TRANSPORT FOR LONDON

LOWER THAMES CROSSING – COMMENTS ON SUBMISSIONS MADE AT DEADLINES 6A AND 7

DEADLINE 8: 5 DECEMBER 2023

E. Work No. 9Z (Sheet 66) – Walking, Cycling, Horse Rider bridge over A127

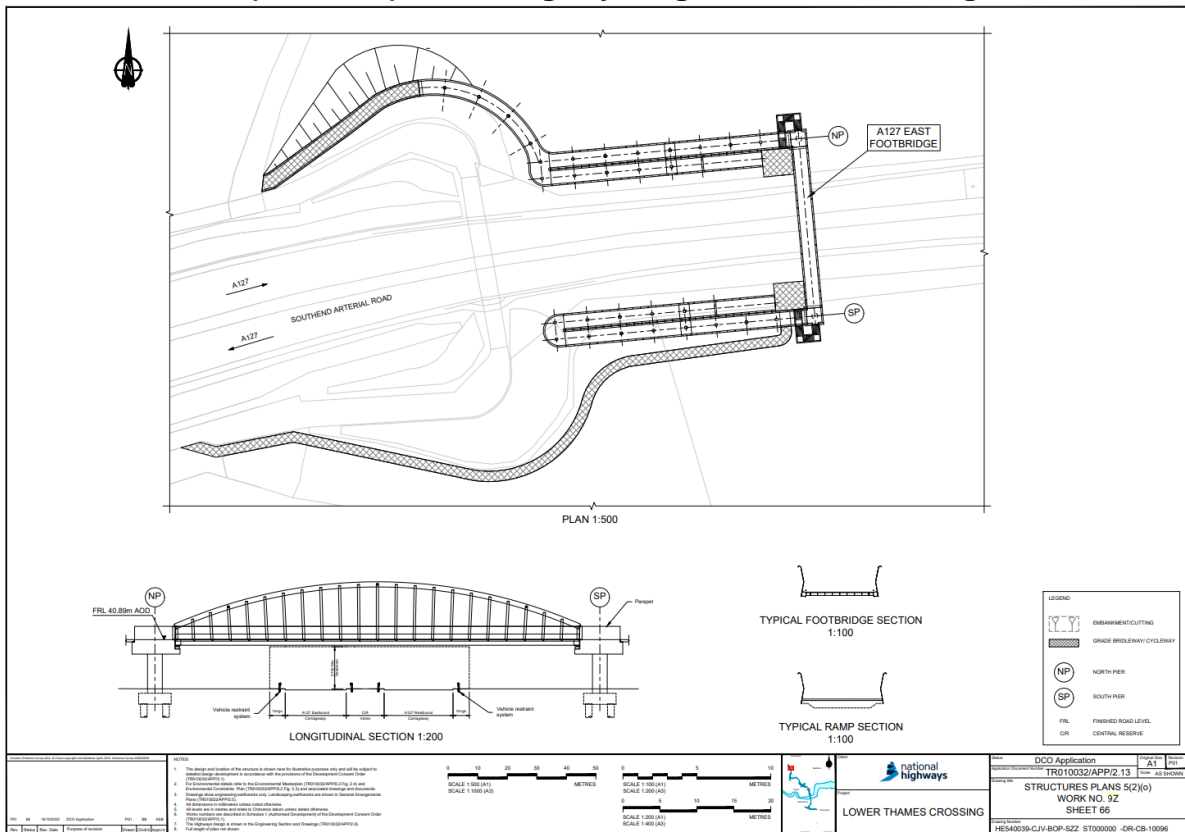
- 4.4 The Applicant maintains its position regarding the walking, cycling and horse-riding bridge over the A127 west of the M25, stating that its provision is only in response to stakeholders to deal with historic severance, not part of mitigation for the Project. TfL continues to dispute that the bridge is required only to deal with historic severance and not also to mitigate the severance caused by the Project, due to the introduction of free-flow slip roads at M25 Junction 29 removing the Non-Motorised User (NMU) route around the south of the roundabout. As stated on page 78: “the Applicant acknowledges that the introduction of dedicated slip lanes from the A127 westbound to M25 southbound and from the M25 northbound to A127 westbound will sever the existing footway links through the south side of the junction” – so this is a clear admission that the Project causes severance here.

- 4.5 The Applicant implies that the existing uncontrolled crossing of the A127 at the junction with Folkes Lane and Front Lane remains available, so NMUs could use this to access the route around the north side of the M25 Junction 29 roundabout. TfL’s view is that the Project adds substantial additional traffic volume to this section of the A127 which will increase the difficulty for vulnerable users to cross safely without a grade-separated facility. This point is demonstrated by the table below which shows the forecast substantial increase in traffic flows on the A127 at this location extracted from modelling shared by the Applicant with TfL, with the changes highlighted in yellow..

- 4.6 The table above shows that even in the opening year (modelled as 2030), there is a substantial increase in traffic in each direction on the A127 past the existing uncontrolled crossing, particularly in the AM peak with around 700 additional PCUs in each direction (a combined total of 1400 extra PCUs in total that a user of this crossing would need to navigate. Therefore, TfL asserts that the Project causes both direct severance on the south side of the M25 Junction 29 roundabout, and indirect severance by substantially increasing traffic at this location making it much more difficult to use the uncontrolled crossing safely.
- 4.7 For completeness, TfL’s position on this matter and list of documents where the Applicant has previously acknowledged the severance caused is set out in Paragraphs 3.1 to 3.4 of its written summary of oral comments at ISH10 (REP6-170).
